**HOLLAND
DISTRICT COUNCIL**

Application no: H19/0692/98

Description: Erection of Dutch light
glasshouse.

Amendment: Turn glasshouses round 90 degrees

SITE PLAN
1:500

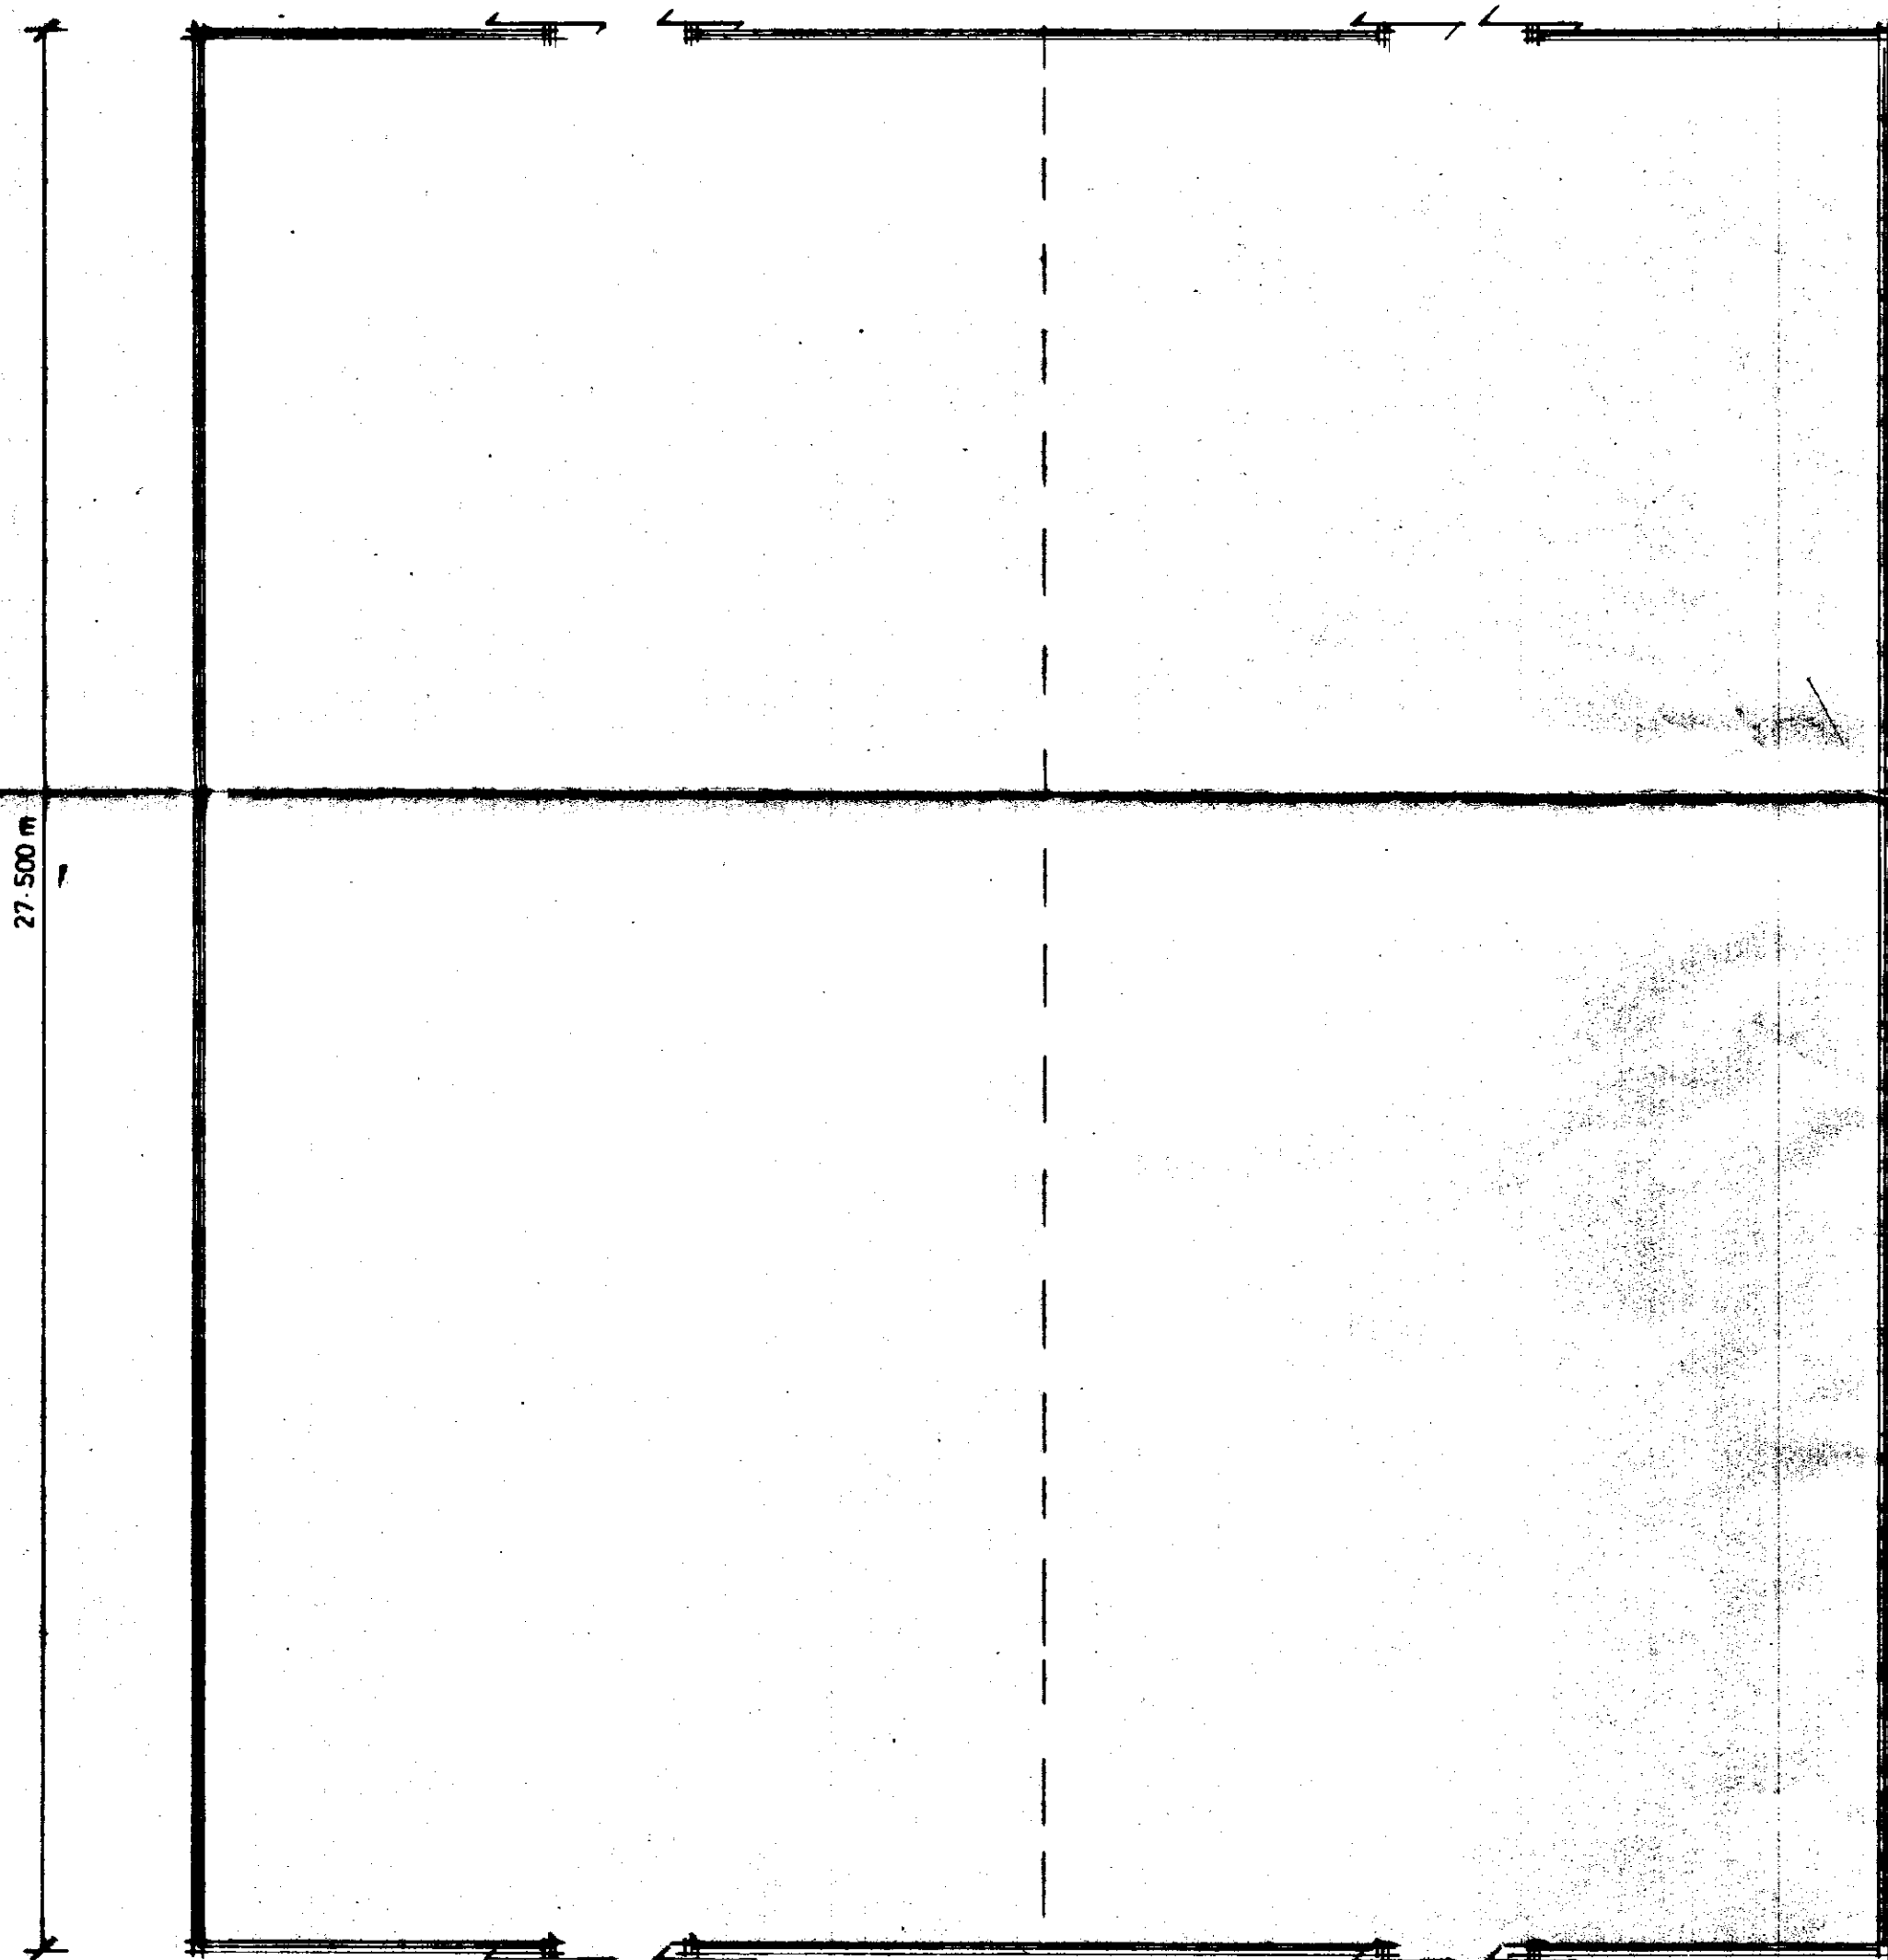
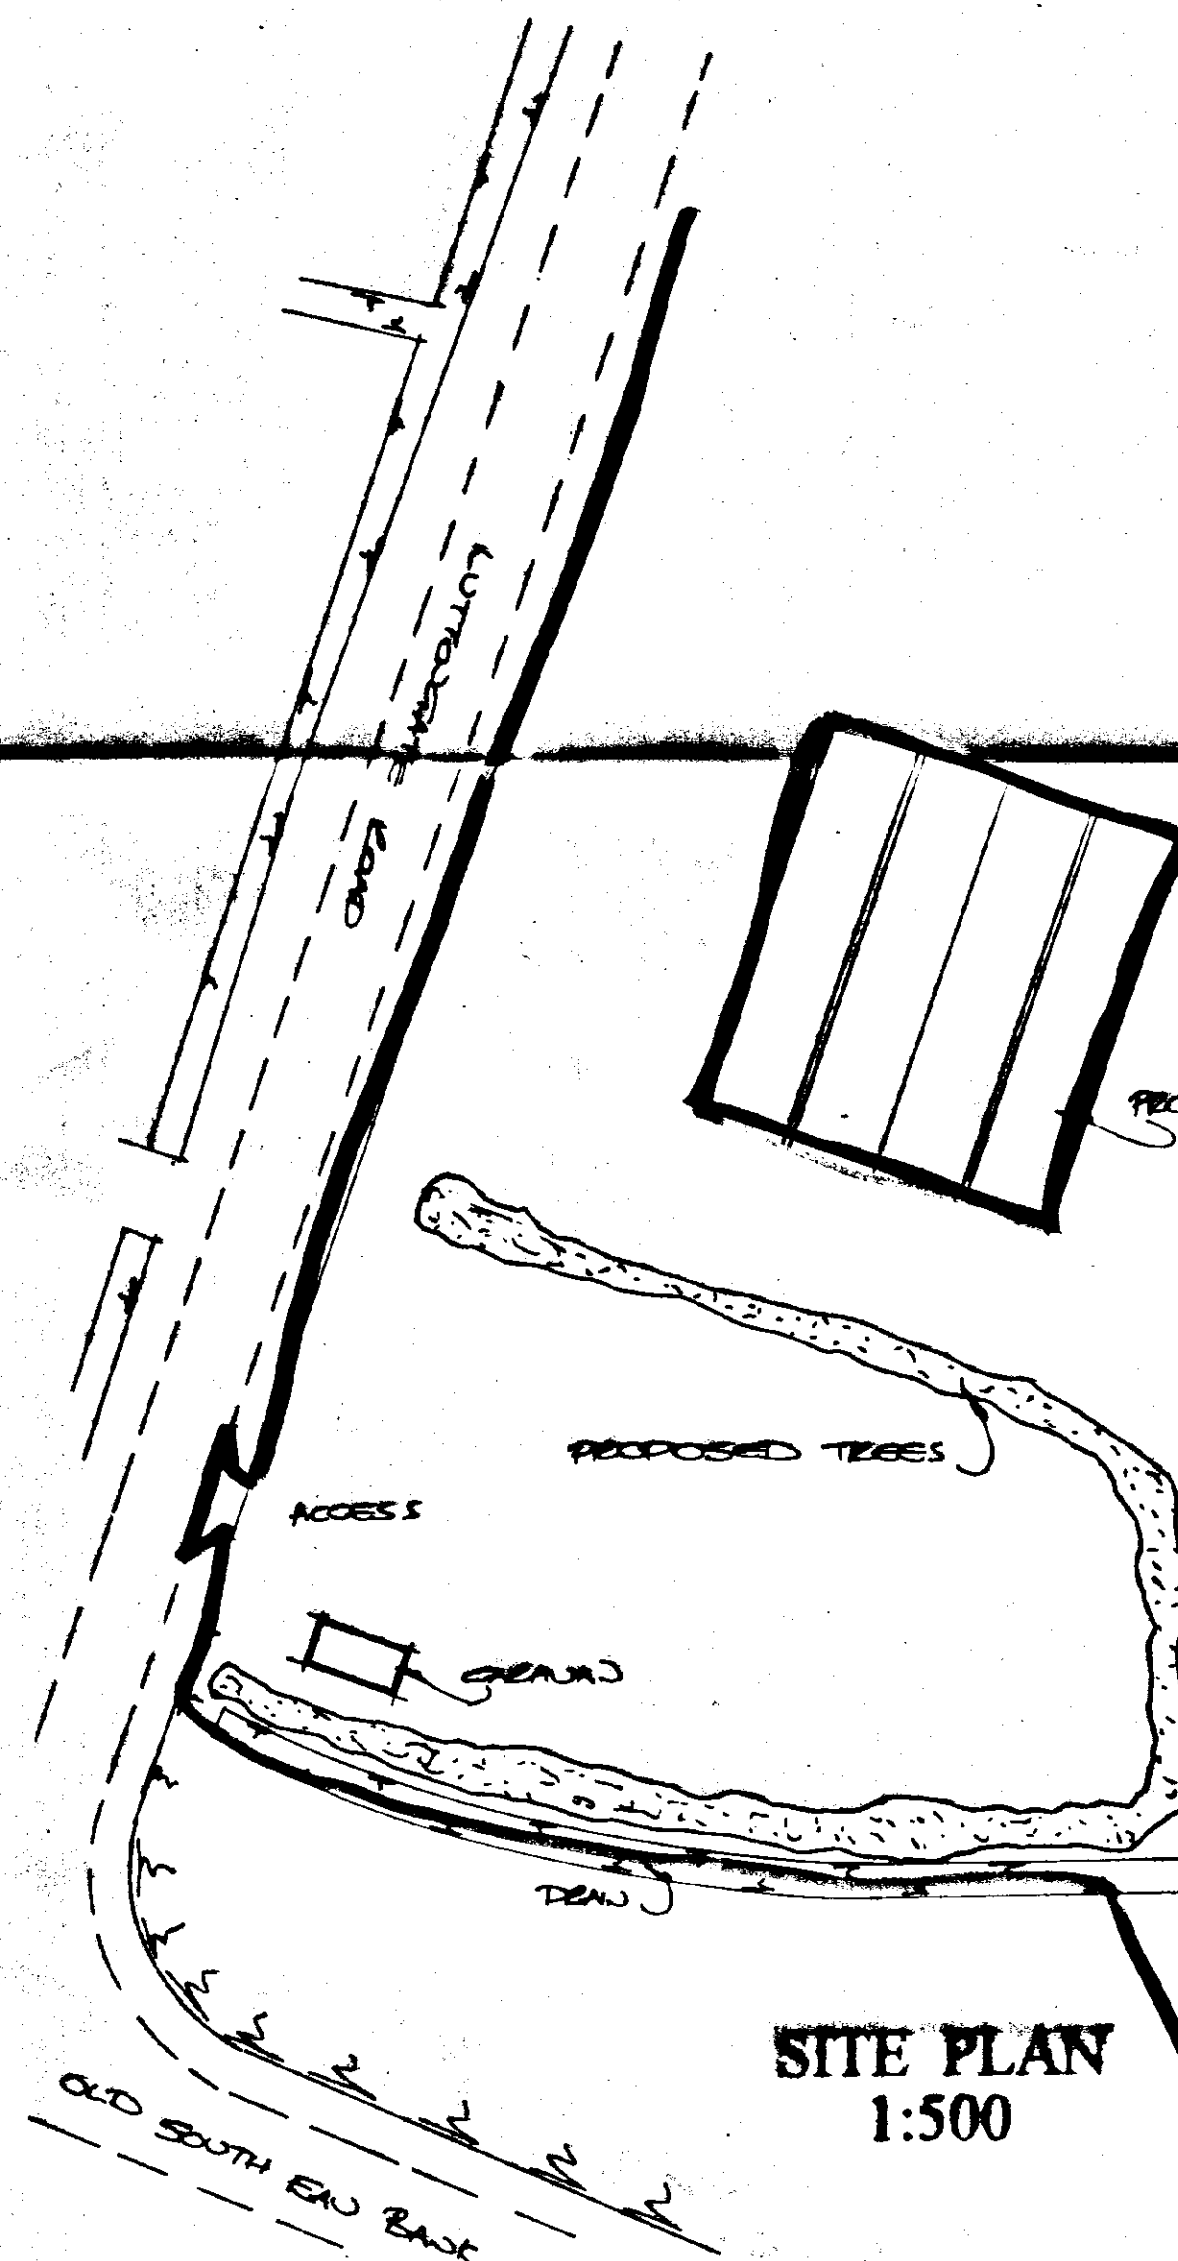
TURN GLASSHOUSES
ROUND 90°
(RETROSPECTIVE)

The amended details submitted in respect of the above proposal have now been considered and there are no objections to the amendment being implemented to the extent described above.
